30/04/2026

Proposed Tween Bridge Solar Farm (Application Reference: EN010148)

Project update in respect of Common Land parcels

Document Ref: 6.4.6.4 AFPP Reg: 5(2)(a) Revision: 2
 PINS Number: EN010148 Drawing Status: Final
 Drawn: LAB Checked: HS Approved: KC Date: 17/04/2026

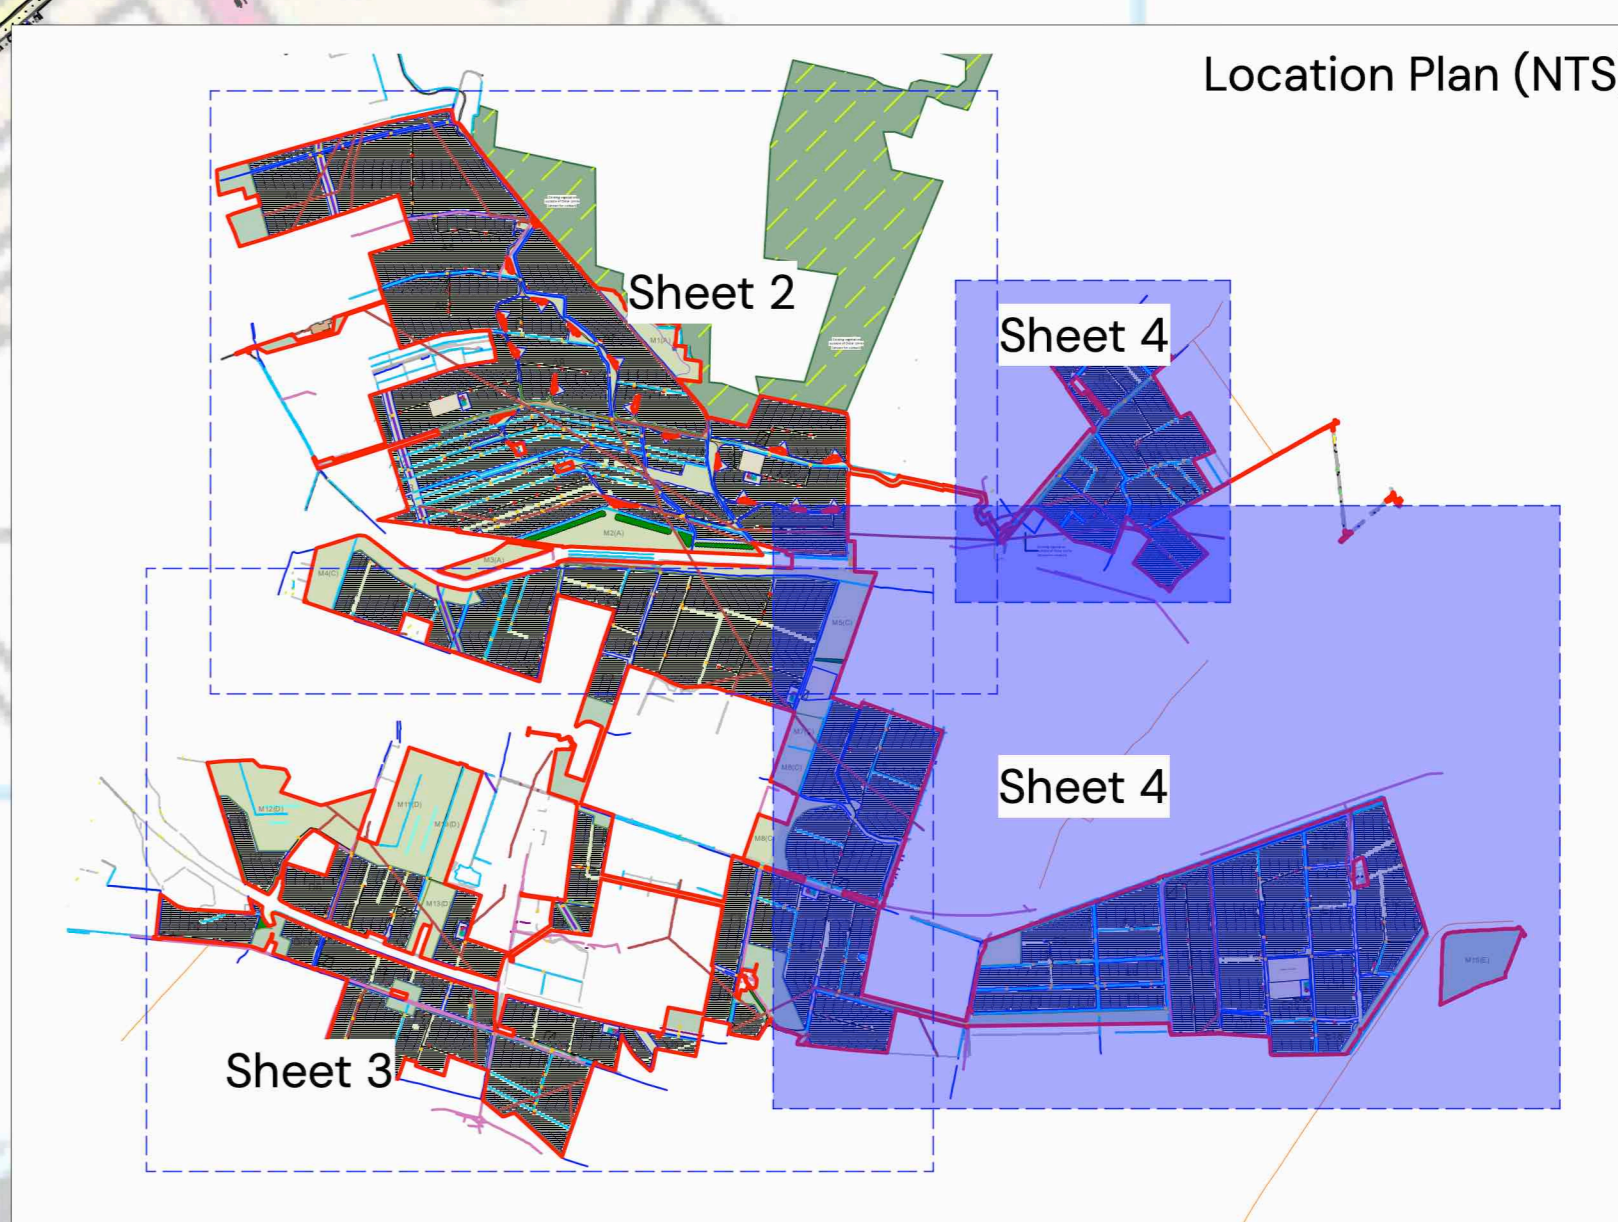
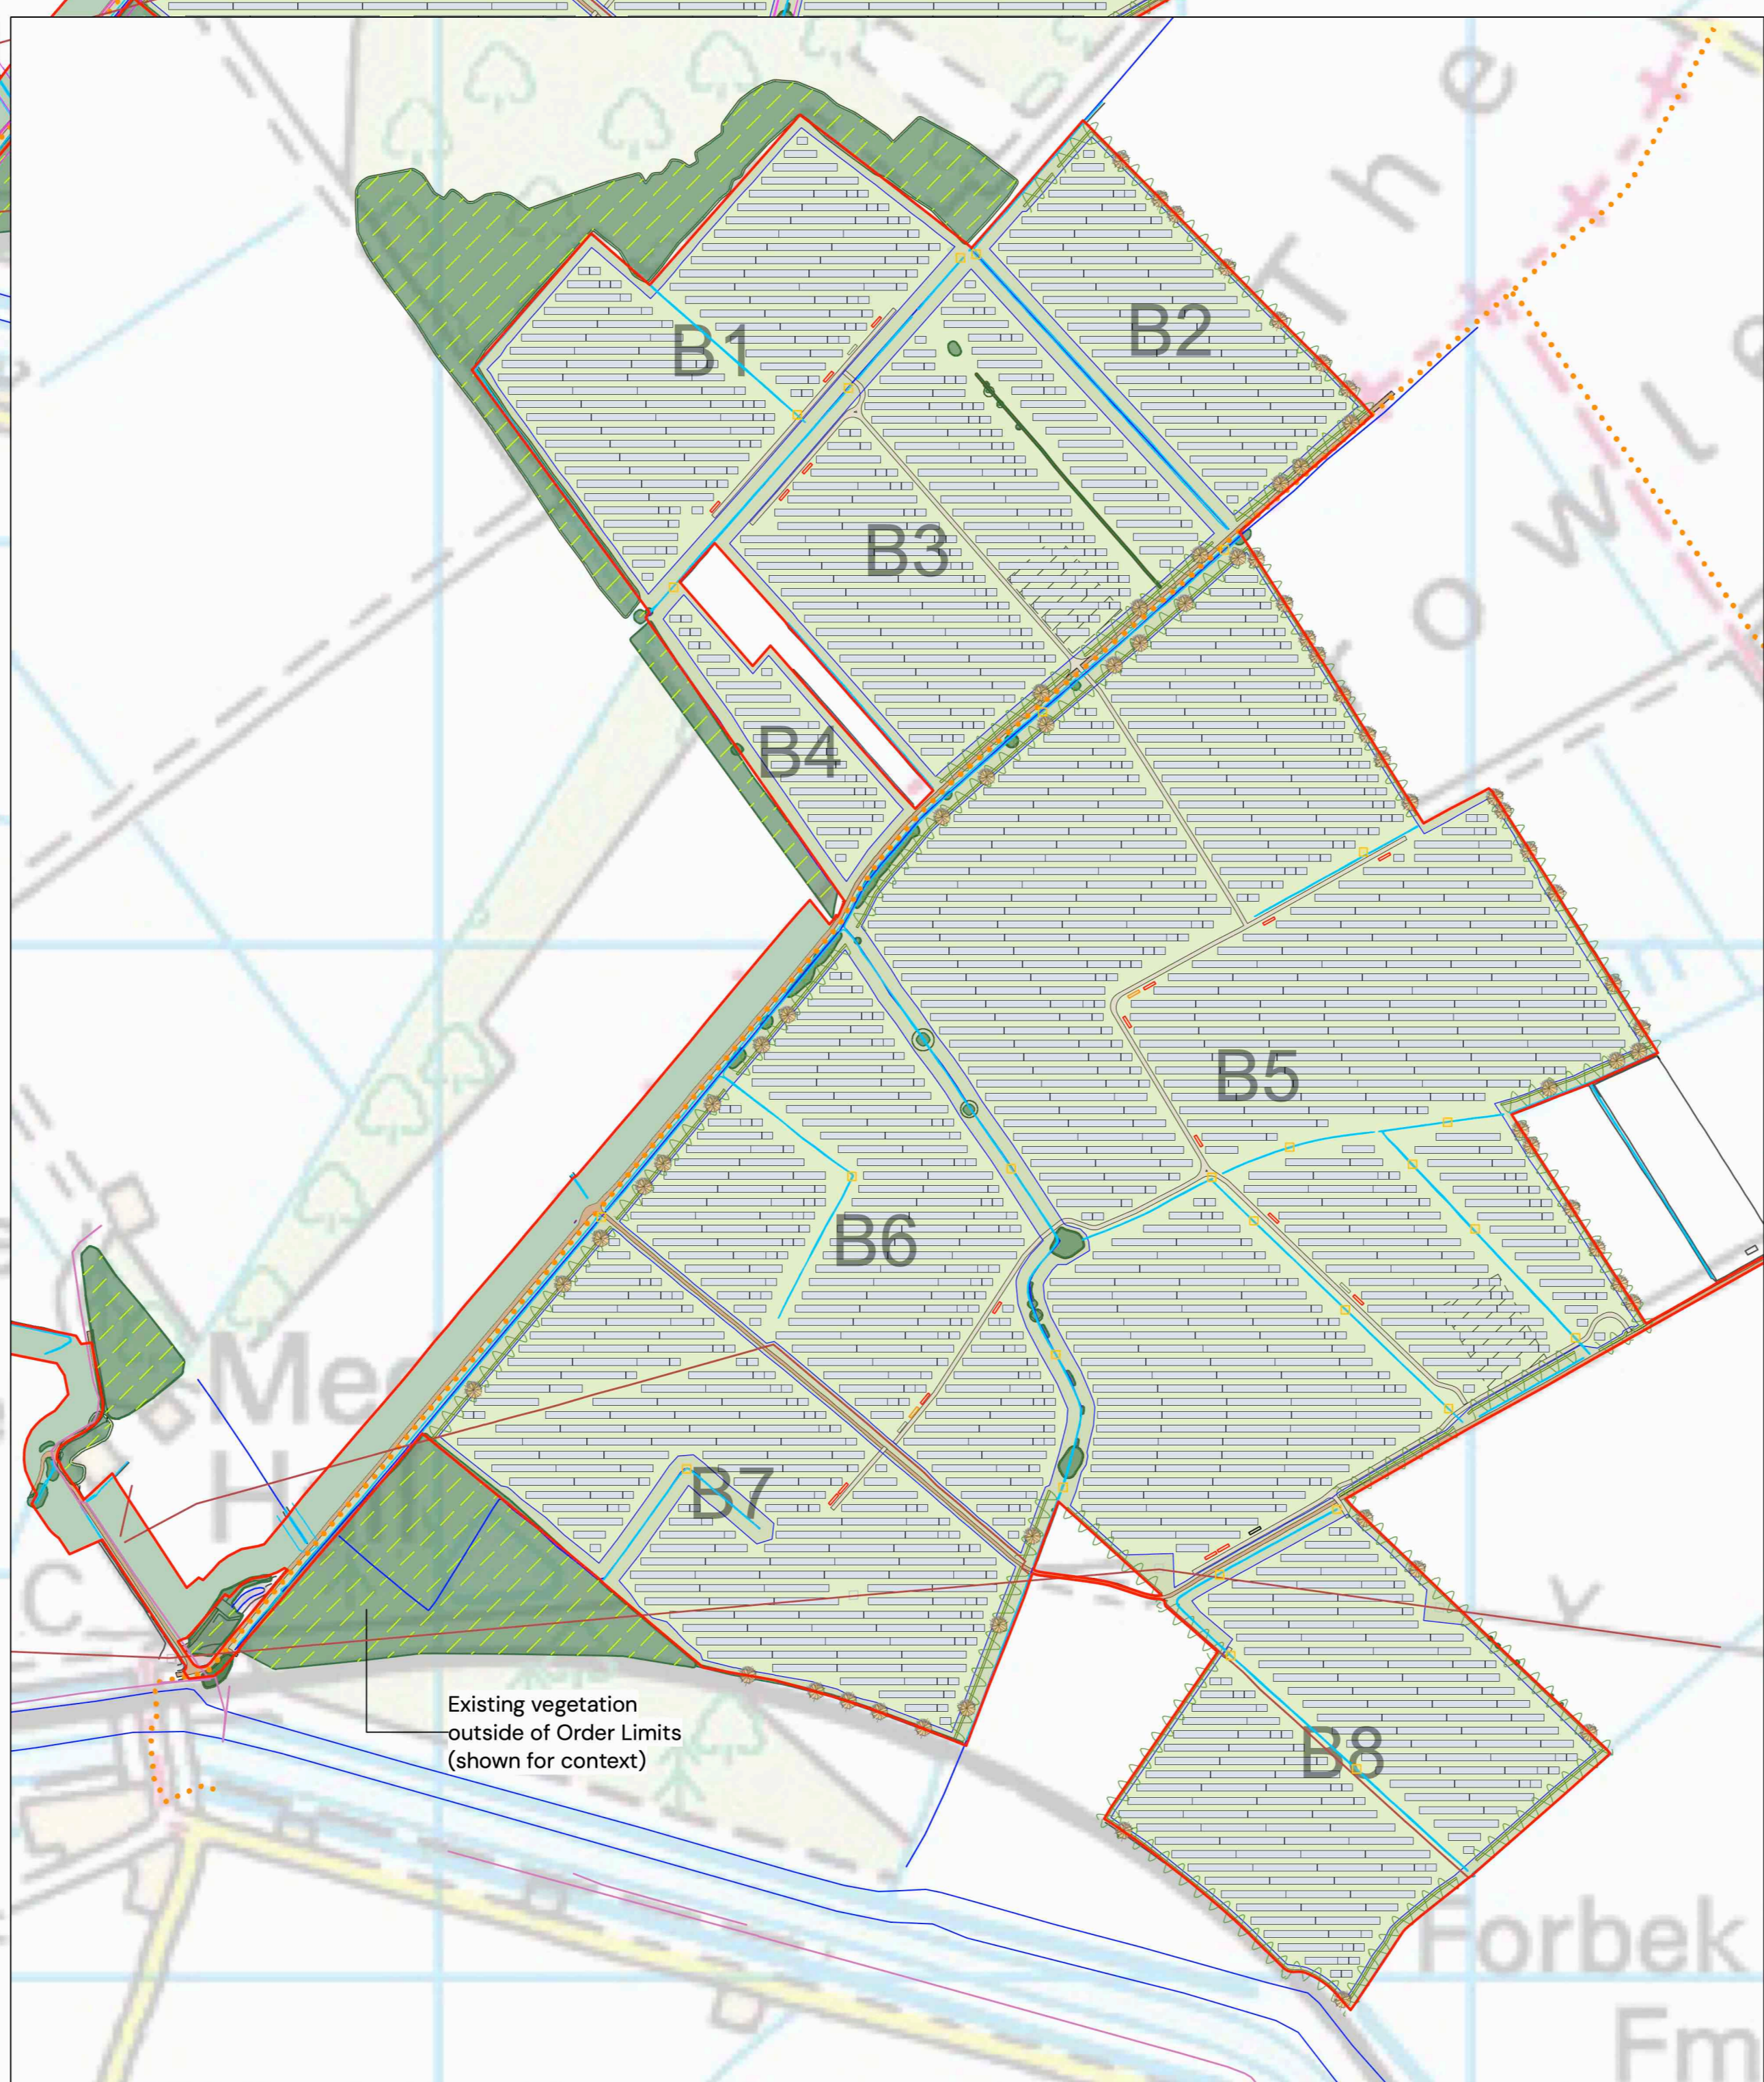
- amending ES Figures 2.2a and 2.2b and ES Figure 6.4 Landscape and Visual Mitigation Strategy [**APP-148**] to identify a minor modification to the proposed permissive path route through mitigation parcel M1(A), so that the route would avoid any interface with parcel 2/A (which is common land), and showing the remainder of the route with the incorporation of fencing;
- amending the oLEMP to describe and show the re-scaled mitigation area identified as mitigation parcel M1(A) and to provide management measures to ensure the BNG requirements would be achieved; and
- amending the BNG calculations (via **ES Appendix 7.12 Biodiversity Net Gain [APP-082]**) to reflect the status of these parcels as CRoW access land to which the public have (in principle) a right of access for the purposes of open-air recreation.

- to implement a minor modification to the proposed permissive path route so that it would avoid crossing parcel 2/A and remains wholly within the limits of parcel 2/16. This would avoid any interaction between the proposed permissive path and common land, therefore addressing the secondary consenting challenges which would arise from fencing the route as Natural England have suggested;

- to fence the remaining extent of the proposed permissive path route, therefore addressing Natural England’s concerns about the potential for the use of the permissive path to undermine the function of the bird mitigation land; and

- to re-scale mitigation parcel M1(A) to avoid the common land, therefore addressing any incompatibility between the use of the land as mitigation for breeding and non-breeding bird species and its status as CRoW access land to which the public have a right of access for the purposes of open-air recreation.
